Change of use from existing leisure use (except lower ground floor which will retain leisure use) to 8 No flats to include extension to form new first floor, alterations to roof space including creation of dormer windows & installation of roof lights (amendment to LU/197/17/PL)

90/91 South Terrace Littlehampton

Thank you for your internet comments made on 13th December 2018 which has been recorded as **'an objection'** with the comments as follows:

Rev	Date	Revision
Client: Dilali Cheddidi		
Project: 90 & 91 South Terrace, Littlehampton, BN17 5LJ Extension and Flat Conversion		
Drawing: South Elevation EXISTING

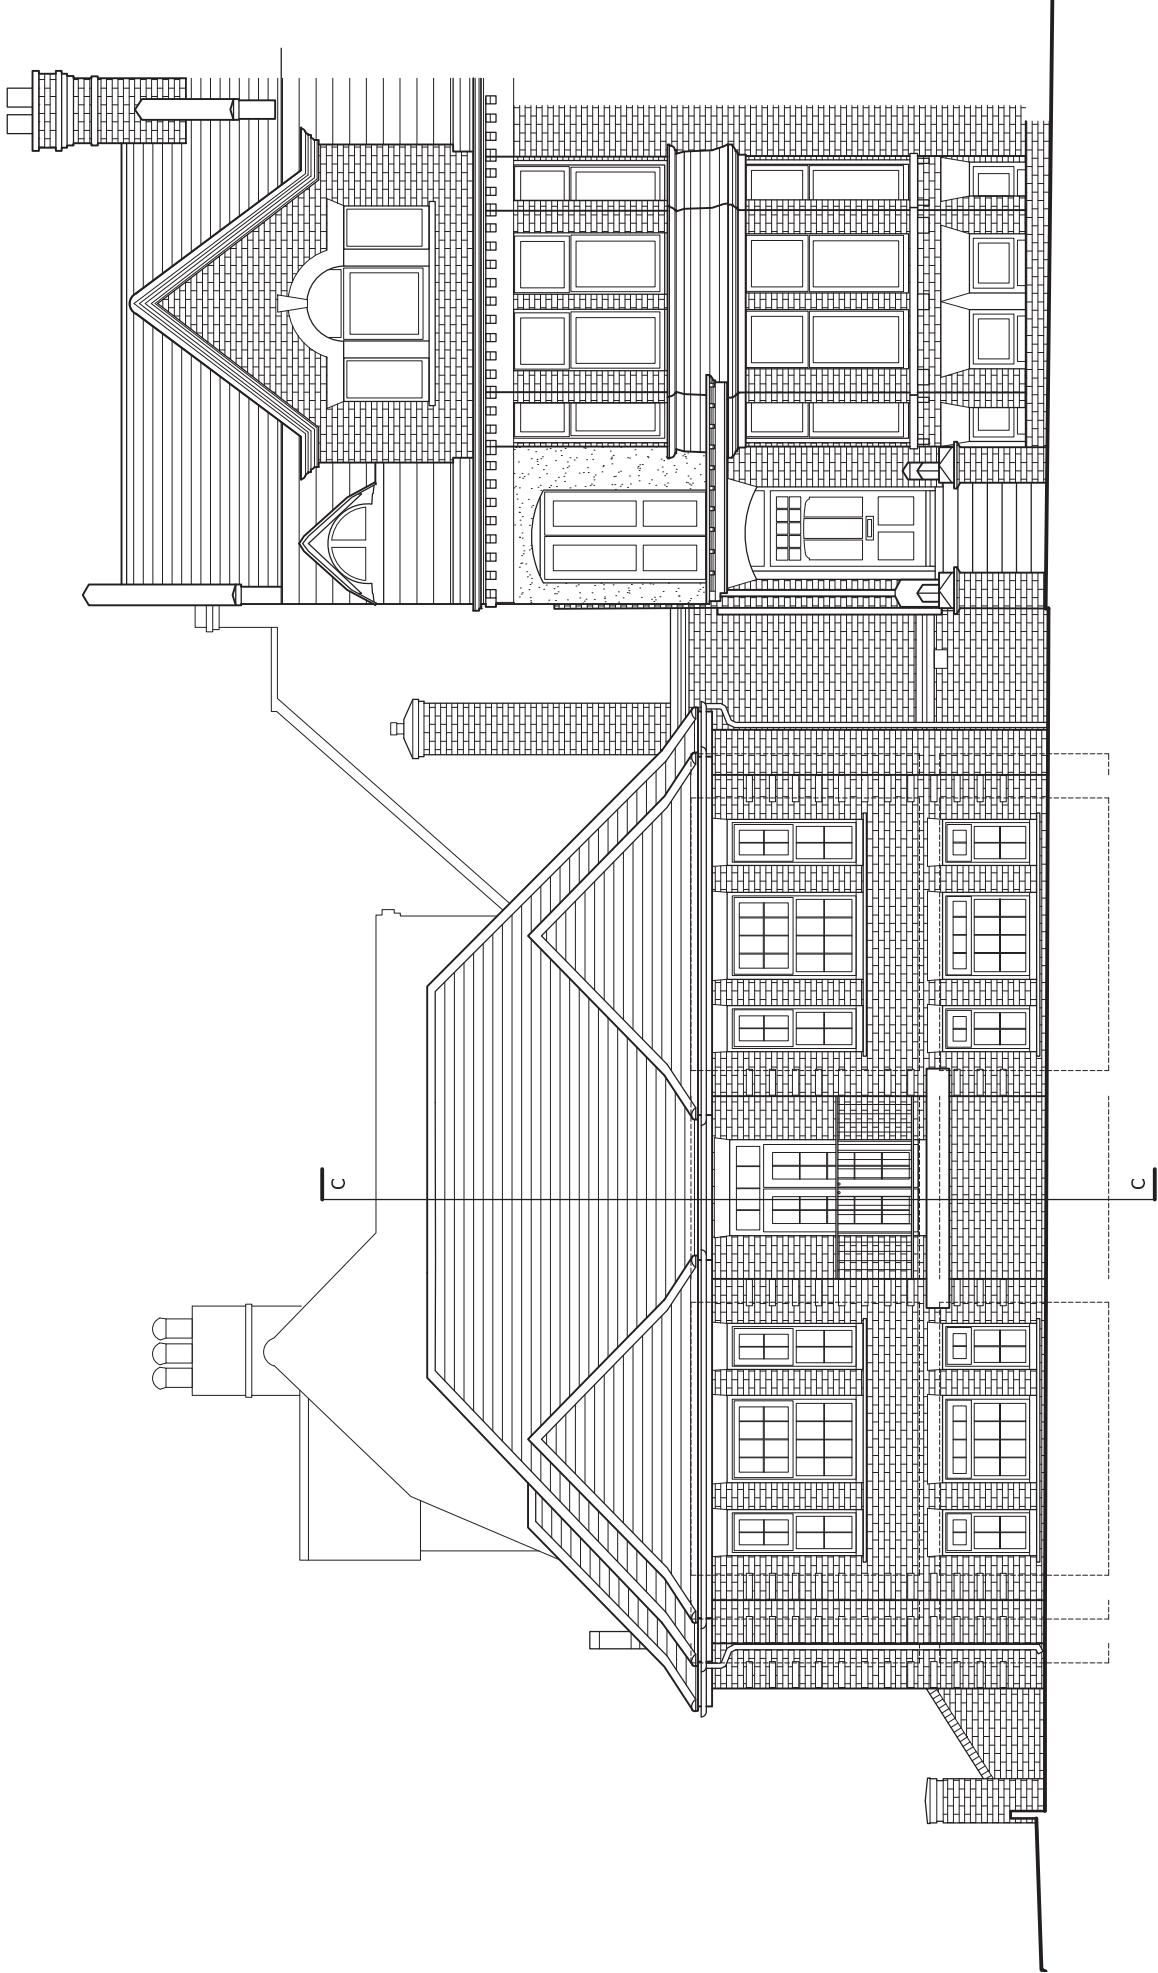
This application was considered by the Town Council's Planning and Transportation Committee at their meeting held on Monday 10th December 2018. The Committee object to the proposals on the following grounds. The design of the southern elevation was considered to be out of character in terms of its appearance compared with the surrounding area. Observing that the number of flats had increased from 6 to 8, the number of parking spaces proposed remained at 4 and the application was therefore considered to lack sufficient on-site parking provision.
